Development Control
Ribbles Valley Borough Council

Your ref: 3/2021/0311
Our ref:
Date: 1st July 2021

Re: Planning Application 21/0311

Address: Brockhall Farm Brockhall Village Old Langho BB6 8BB

Client	Brockhall Farm		
Project	Brockhall Farm redevelopment		
Title	Access mitigation		
Purpose of Issue	<input type="checkbox"/> For Information <input checked="" type="checkbox"/> Preliminary		
Drawn	AJC	Checked	AD
Scale	A4 Plot 1:500	Date	7/1/2021
Drawing No.	J1194 access fig 2	Rev

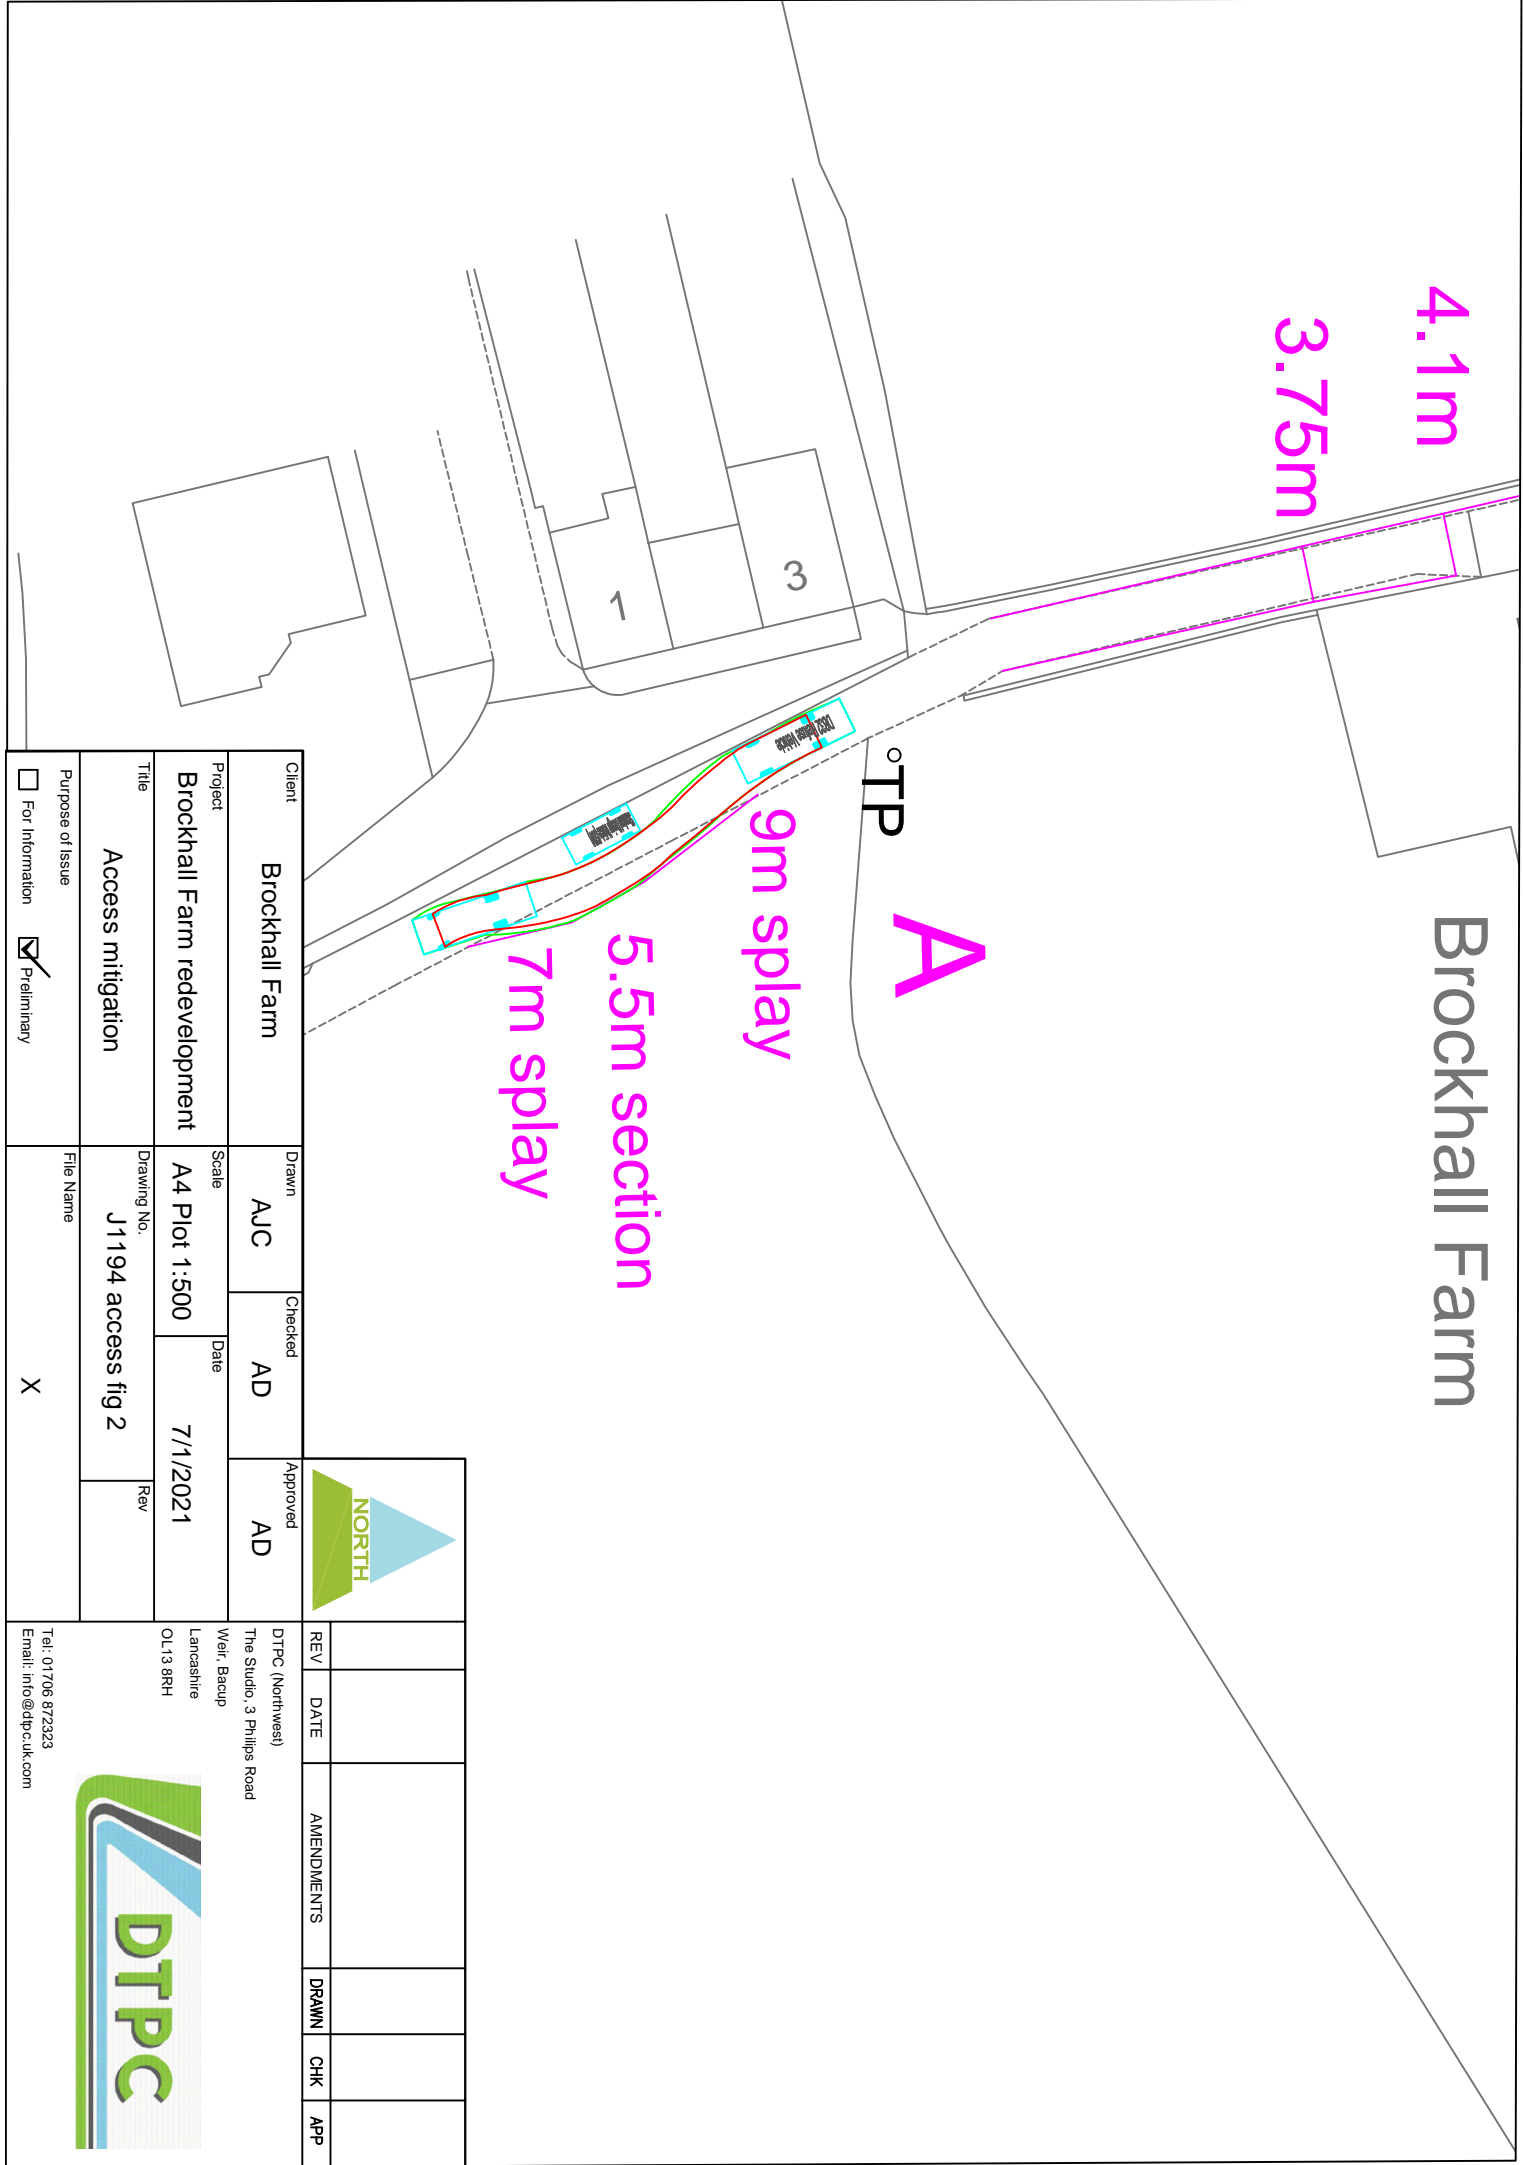
There are however concerns regarding the access along the track to the rear of Larkhill including the lack of pedestrian facilities at the cattle grid to the rear of Bradyll Court.

Whilst a swept path analysis has been undertaken for a refuse collection vehicle for the passing places, there is no indication as to if the rest of the land is to be farmed. It is advised that the passing places should be of sufficiently large enough to accommodate the passing of tractor with trailer and the refuse vehicle.

The existing cattle grid will require up grading to accommodate a suitable access for pedestrians.

It is recommended that a pre commencement survey of the access should be undertaken by the applicant and presented to the Larkhill Residents Group with a view to repairing any damaged that could be attributed to the construction phase of the development. The residents group should be approached to take part in the survey, if the residents group do not wish to partake in the survey this should not be used as a reason not to undertake the survey.
